Annexe 1

Issue Specific Hearing on the Draft Development Consent Order (DC)

28 February 2019 at the Hayward Suite, Molineux Stadium, Waterloo Road, Wolverhampton, WV1 4QR

COMMENTS AND QUESTIONS BY EXAMINING AUTHORITY

Project THE WEST MIDLANDS RAIL FREIGHT INTERCHANGE 2020			
Drawing Status Final			
Drawing Title Road Bridge B4		Drawing Size A1	
Regulation 5 (2) (o)		Document 2.18D	
Drawn TP	Date July 2018	Scale As Shown	Reviewed TL
Drawing No. 1516-0425-WDK-SI-C-301-008			Rev. P17

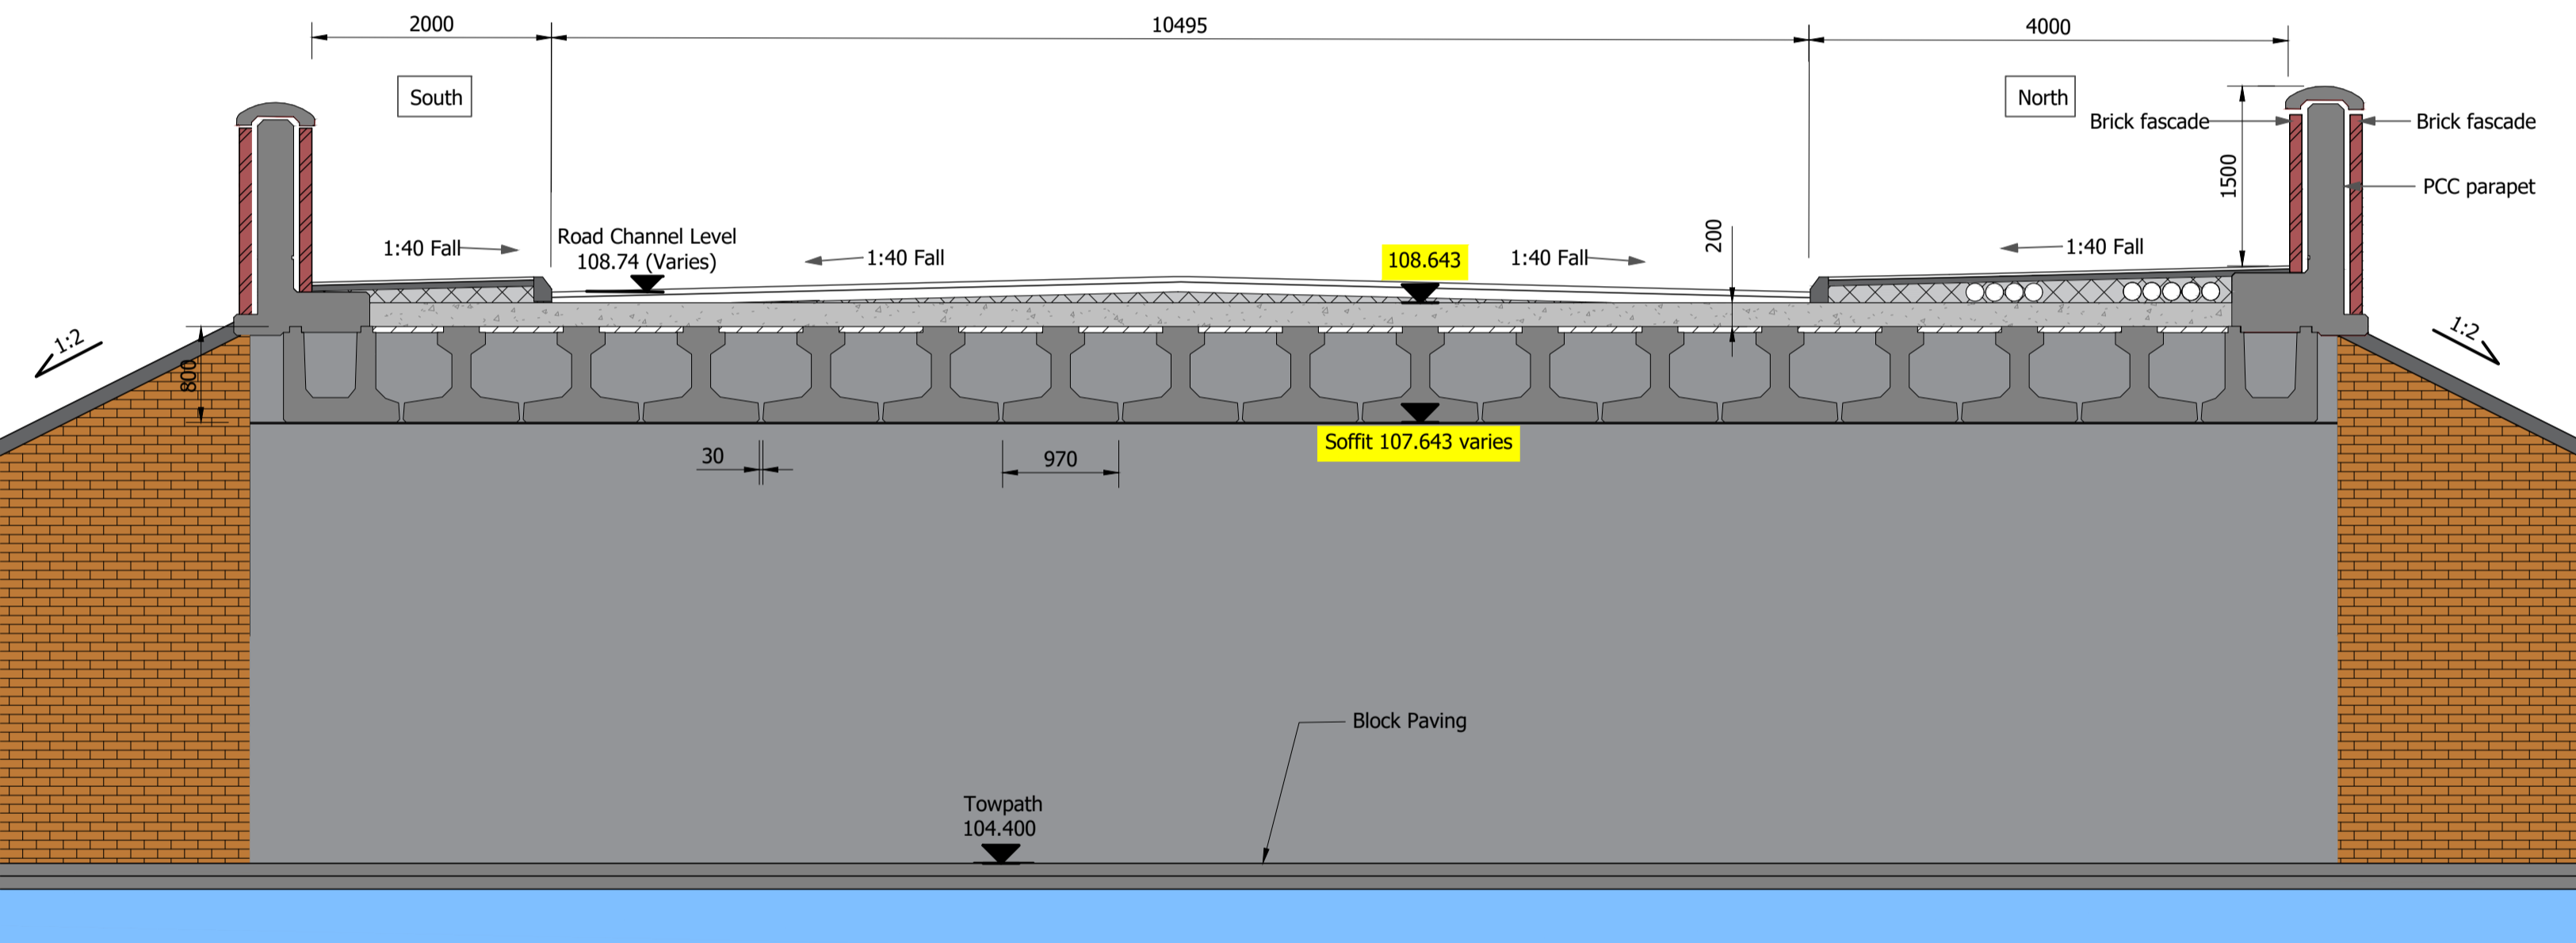
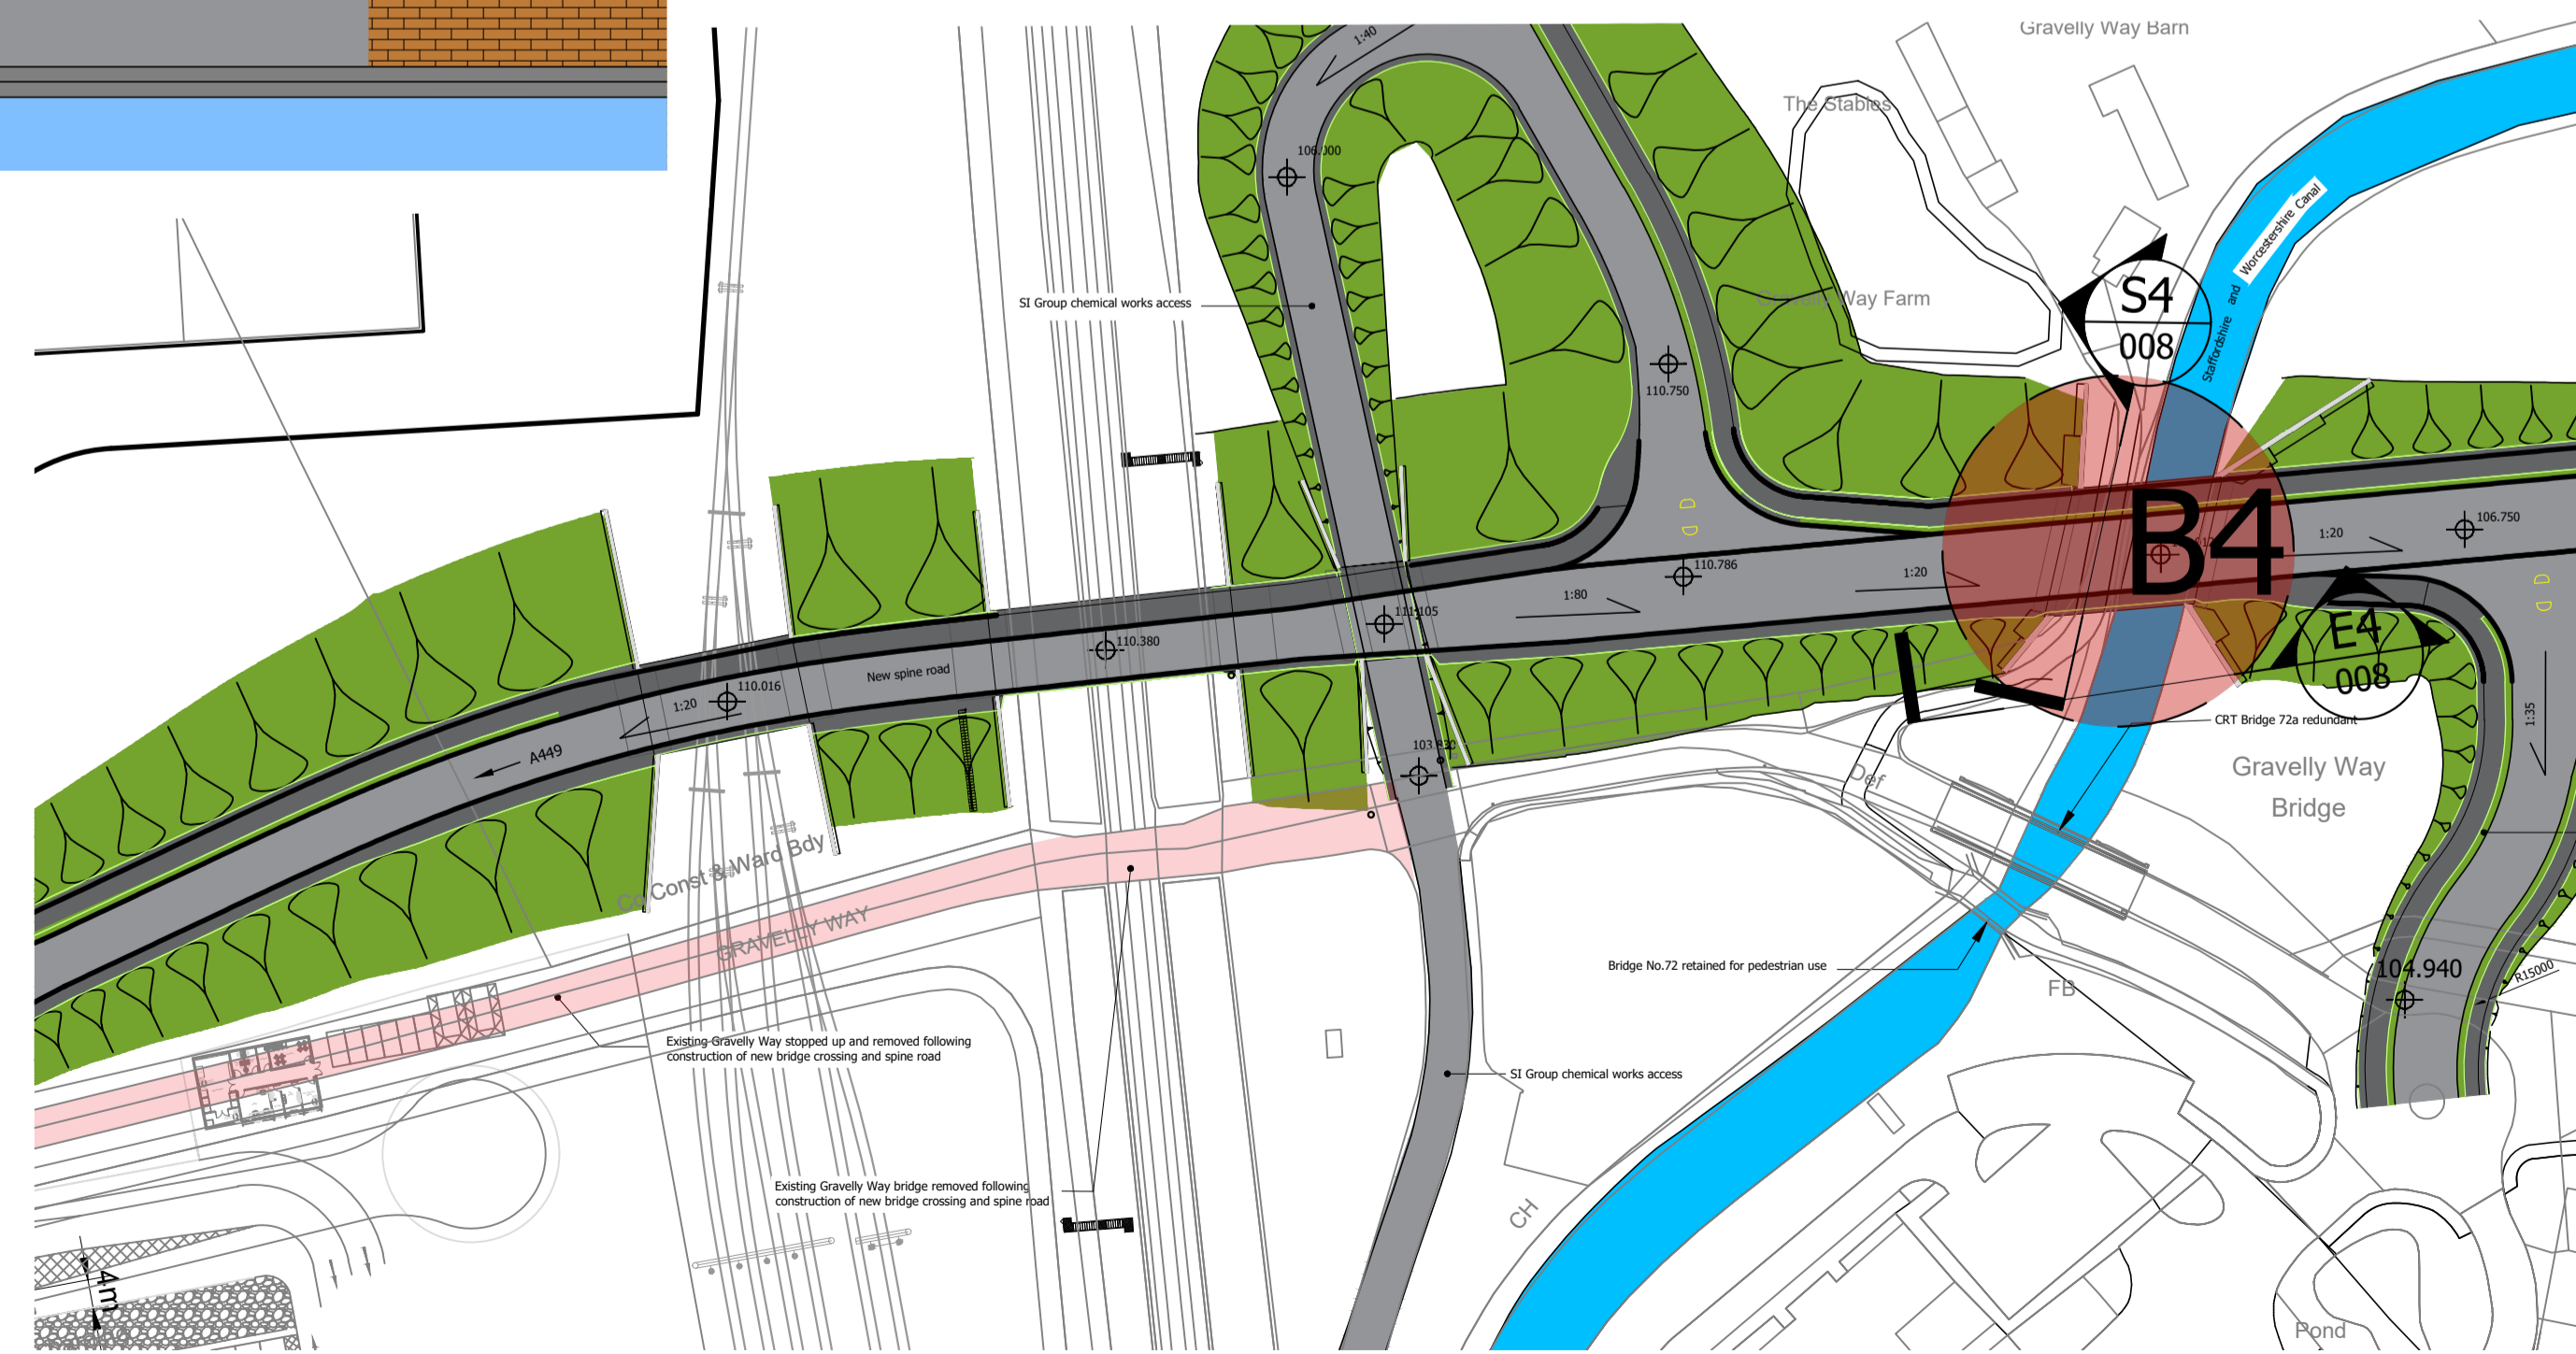
1.10	A4	Applicant	<p>i) How would Clause (b) operate alongside the annotations on the Bridge Plans which indicate detailed levels for the underside, deck and other key elements of the proposed bridges and set minimum clearance levels for the underside of bridges?</p> <p>ii) Would there be a risk that the flexibility provided by Clause (b) might operate in tandem with that provided by Clause (c) (i.e. in relation to a bridge over part of the railway works) to result in an upwards deviation in the level of such a bridge by 3 metres?</p> <p>iii) Has the full degree of flexibility provided for in A4 been assessed in the ES on a worst case basis?</p>
